An
Bord
Pleanála

Inspector's Report ABP-306660-20

Whether the extension of chalet to rear of structure by 92m². Finishes to match existing structure and new entrance door to Eastern Elevation is or is not development or is or is not exempted development.

Mullarkeys' Cliff Road, Ardmore, Co. Waterford.

BUILDING PLAN

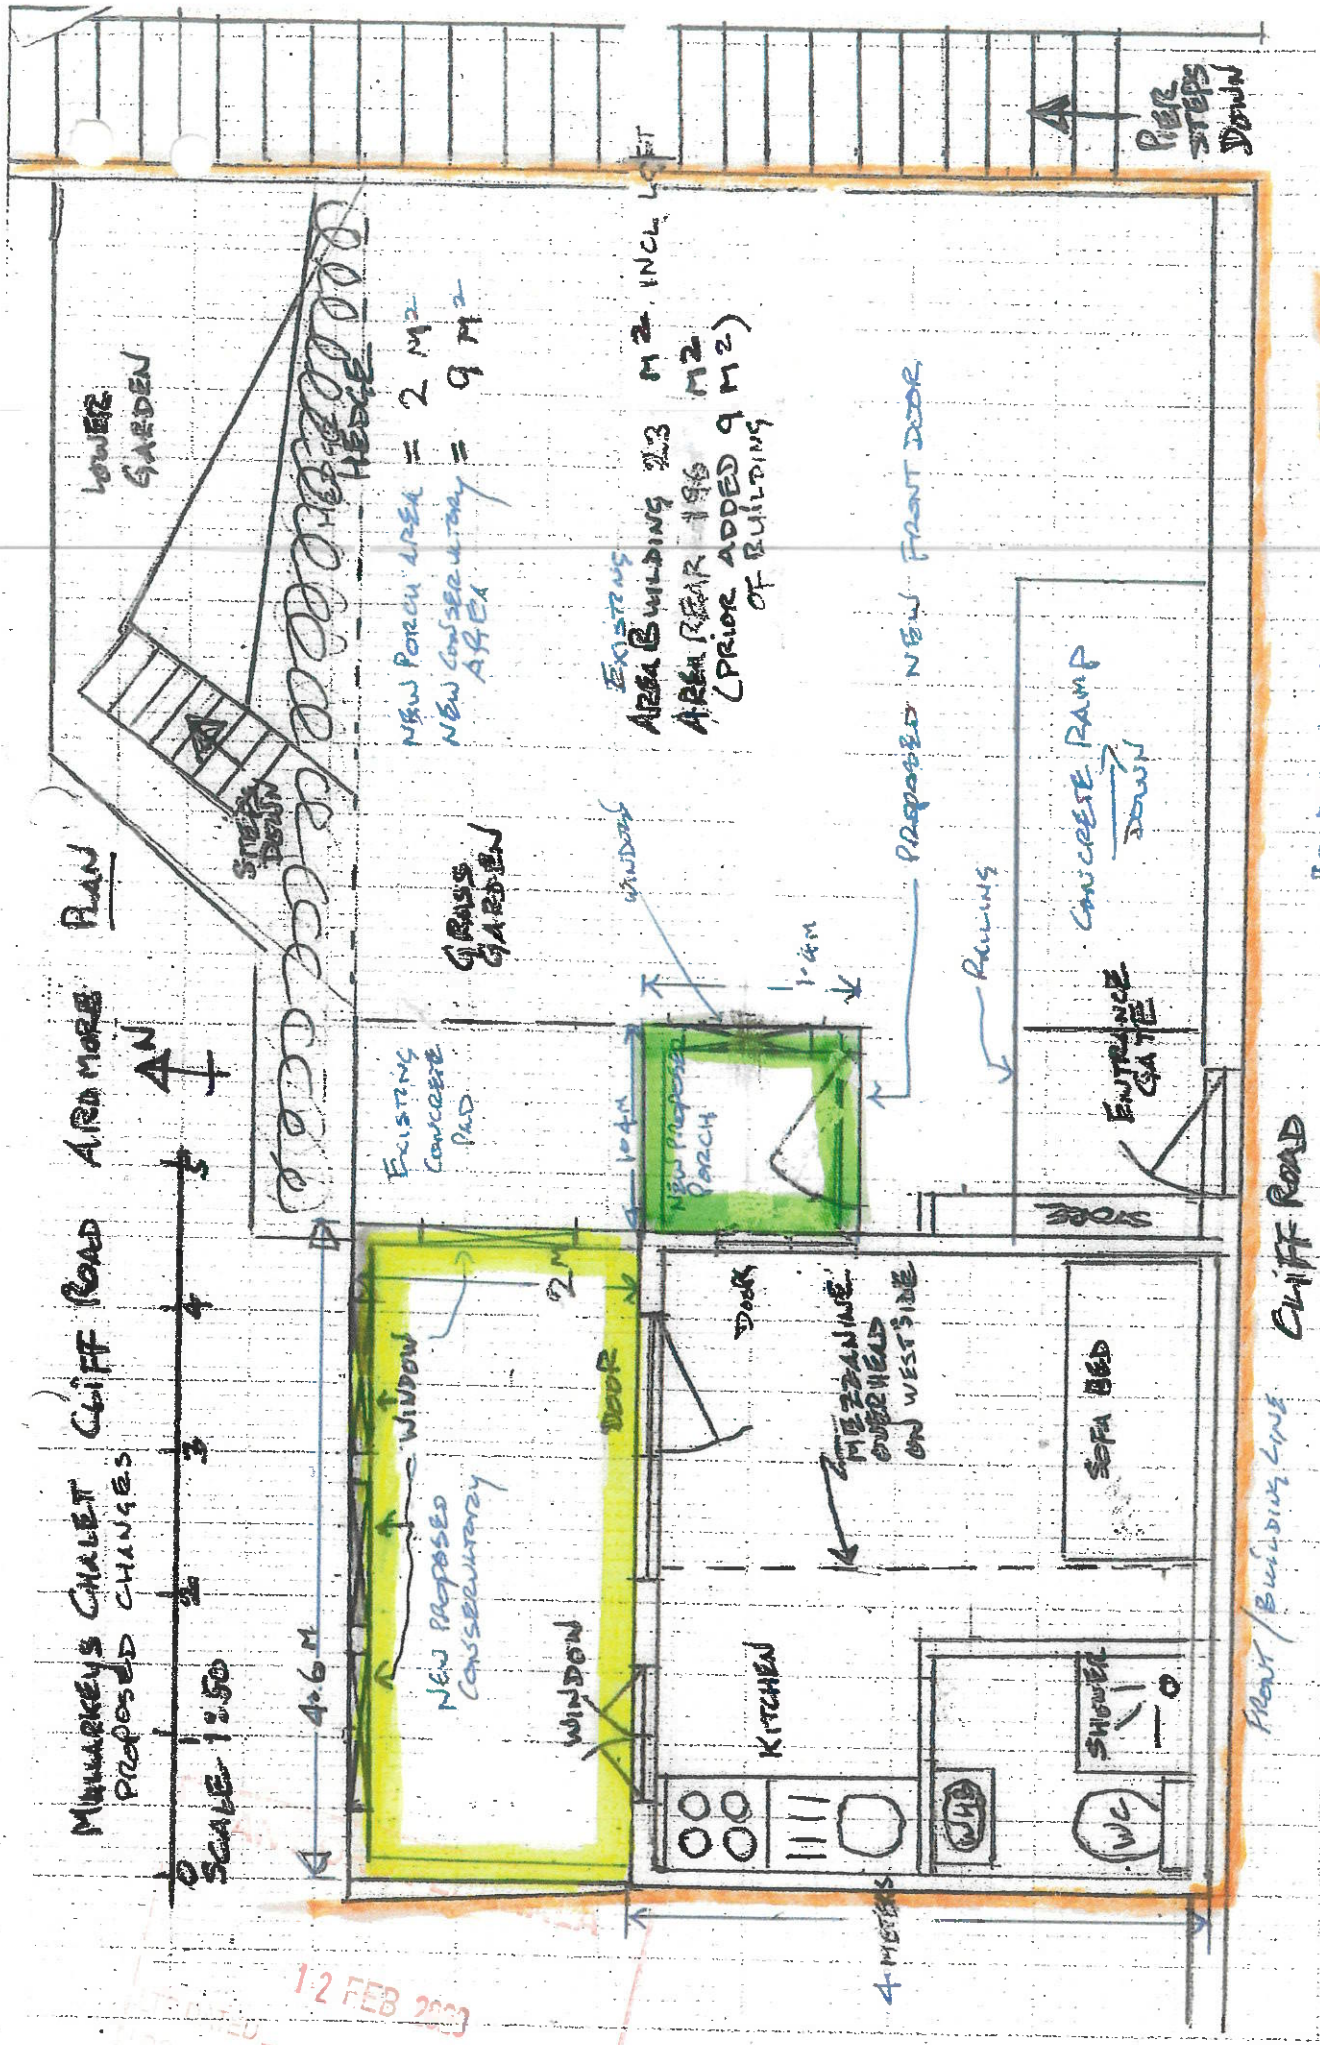
- 8.3.1. Notwithstanding the view set out in 8.2 above that the proposed conservatory extension would be to the front rather than the rear of the existing chalet structure on site, there are a number of conditions and limitations attached to Class 1 that are in my opinion relevant. Specifically, I do not consider that there is 25 sq. metres of usable open space proposed to be retained to the rear of the building line. The referrer contends that the minimum 25 sq. metre open space area is met by virtue of the fact that there would be 196 sq. metres of the site retained to the rear of the building. However, the nature of this site area is that it is steeply sloping cliffs which are not usable open space areas and which have no amenity value. It is therefore my opinion that the only part of the site which can be considered as open space serving the house is that which is level and accessible.

- 8.3.2. The current layout is such that there is c.24 sq. metres of open space in the main upper garden area with a further c.2.5 sq. metres at the lower level. With the proposed development, the rear of the existing building line would be reduced to c.14.5 sq. metres (7.25 by 2.0 deep) and the area to the rear of the new building line formed by the conservatory structure would comprise only the 2.5 sq. metres at the lower garden level. Condition and Limitation 5 relating to Class 1 requires as follows:

- 8.3.3. The proposed development would result in the area of private open space to the rear of the existing rear building line being reduced to less than 25 sq. metres and the area to the rear of the house (rear of the proposed extension) would comprise only the 2.5 sq. metre lower garden. It is therefore considered that the restriction on exemption relating to retained open space is not met and that the exemption provided for in Class 1 of Part 1 does not therefore apply.
- 8.3.4. I have reviewed the other conditions and limitations attaching to Class 1 of Part I of the Second Schedule and consider that these would be complied with. Specifically, the development is less than the 40 sq. metres maximum specified and there would not be any new windows created that would be within 1 metre or less of any boundary.

ELEVATION FROM SEA (NORTH)

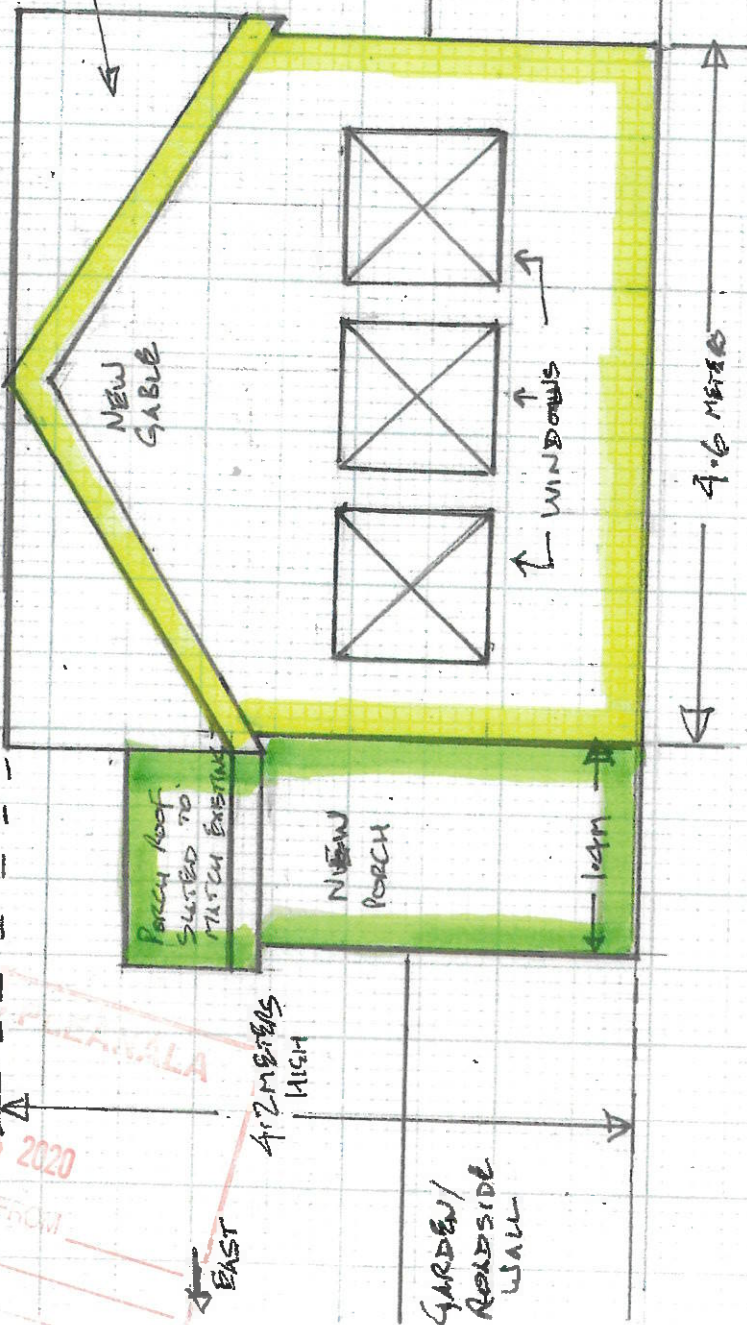
- 8.2.8. In the case of the subject site, the existing chalet fronts directly onto Cliff Road and the only access to the site is from Cliff Road, both of which would support the contention of the referrer that this is the front of the house. Against this however, the primary windows and aspect of the house is to the north over the coast and there are no windows or other openings in the south facing elevation that fronts Cliff Road. The existing access into the chalet is also currently on the southern side facing the sea and the garden / open space area is primarily to the side (east).

- 8.2.9. On balance therefore, and having particular regard to the fact that the main entrance to the building is on the south facing (sea) side, that the elevation to the public road (north facing) is a blank elevation and that the pedestrian access to the site accesses the north facing elevation, it is my opinion that the north facing elevation facing the sea is the front elevation of the property and that the elevation facing the road is the rear. It is therefore my opinion that the proposed conservatory extension would be to the front of the structure and would not come within the scope of Class 1 of Part I of the Second Schedule. In the event that the Board do not agree with this interpretation, section 8.3 sets out the extent to which this aspect of the proposed development would comply with the restrictions listed relating to Class 1 of Part I.

EAST

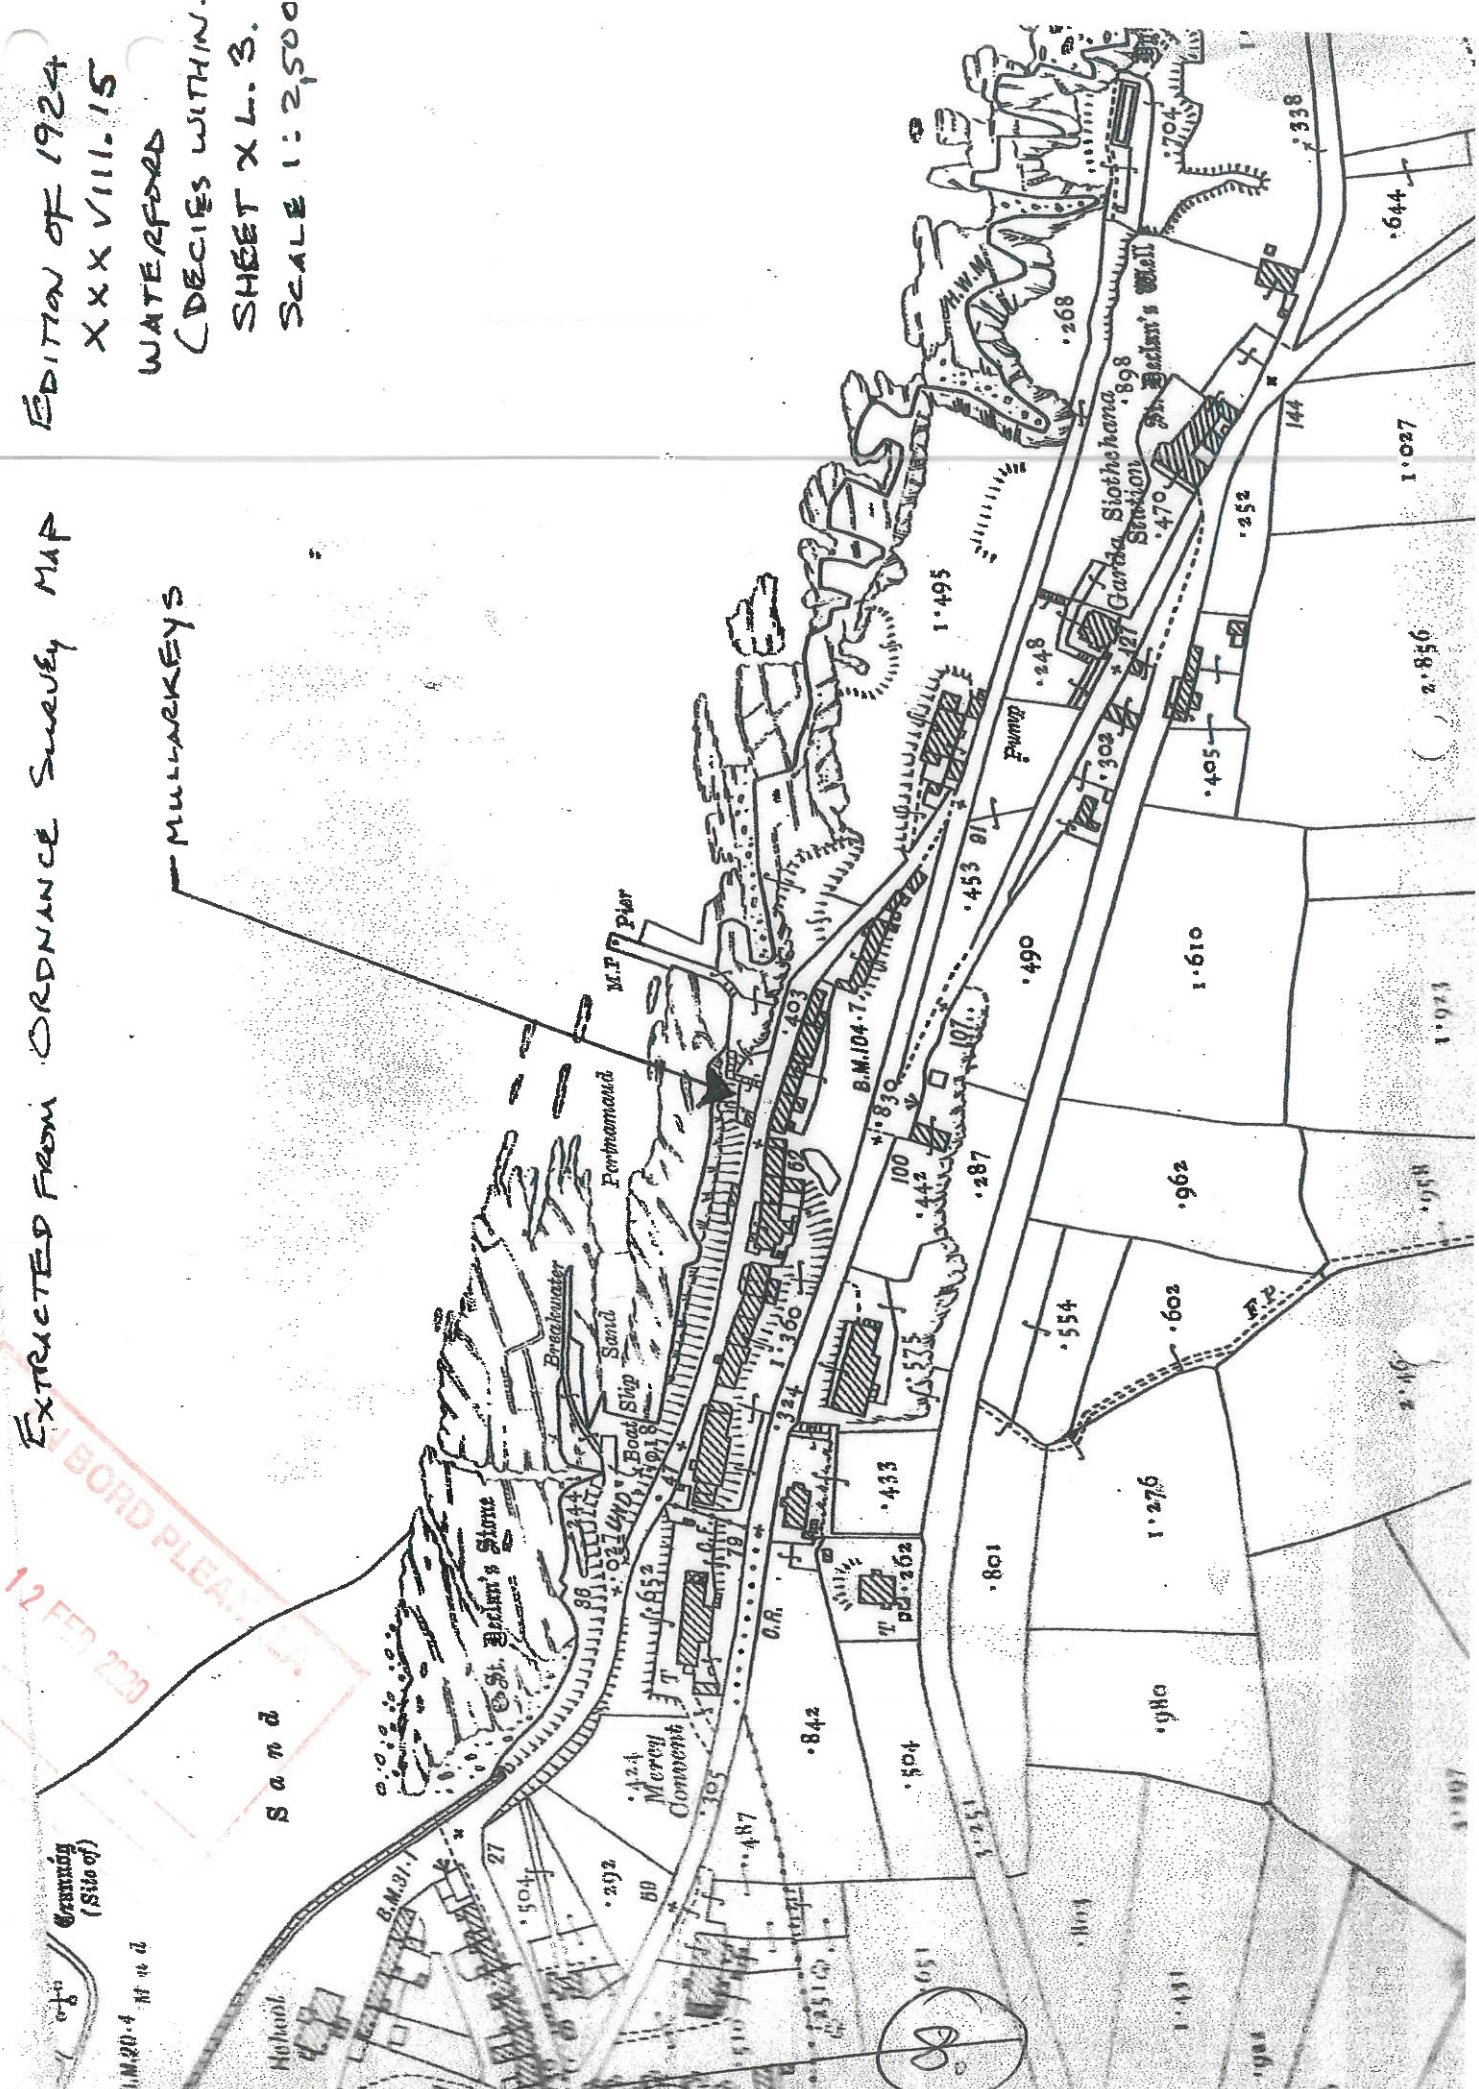
- 8.2.10. The exemption under Class 7 of Part I of the Second Schedule relates to a porch and states as follows, '*The construction or erection of a porch outside any external door of a house*'. The structure proposed to be erected to the eastern elevation of the existing chalet in my opinion comprises a porch within the meaning of this class. I do however note the fact that the structure proposed would not serve an existing external door, and that it is proposed as part of the development that a new door

opening would be created in the position of the existing window. I do not therefore consider that the proposed development complies with a strict interpretation of the wording of Class 7 of Part I on the basis that the structure would not serve an existing external door and that the opening of the door would in itself need to be taken under exempted development. In the event that the Board do not agree with this interpretation, section 8.3 sets out the extent to which this aspect of the proposed development would comply with the restrictions listed relating to Class 7 of Part I.

- 8.3.5. Notwithstanding the view set out in 8.2 above that the proposed porch extension would not be to an existing doorway and is not therefore exempted development, the proposed structure is in my opinion consistent with the conditions and limitations specified in Class 7 of Part I. Specifically, the structure would be more than 2 metres from any public road, the floor area would not exceed 2 sq. metres and the height of the proposed pitched roof structure would be less than the 4 metres maximum specified.
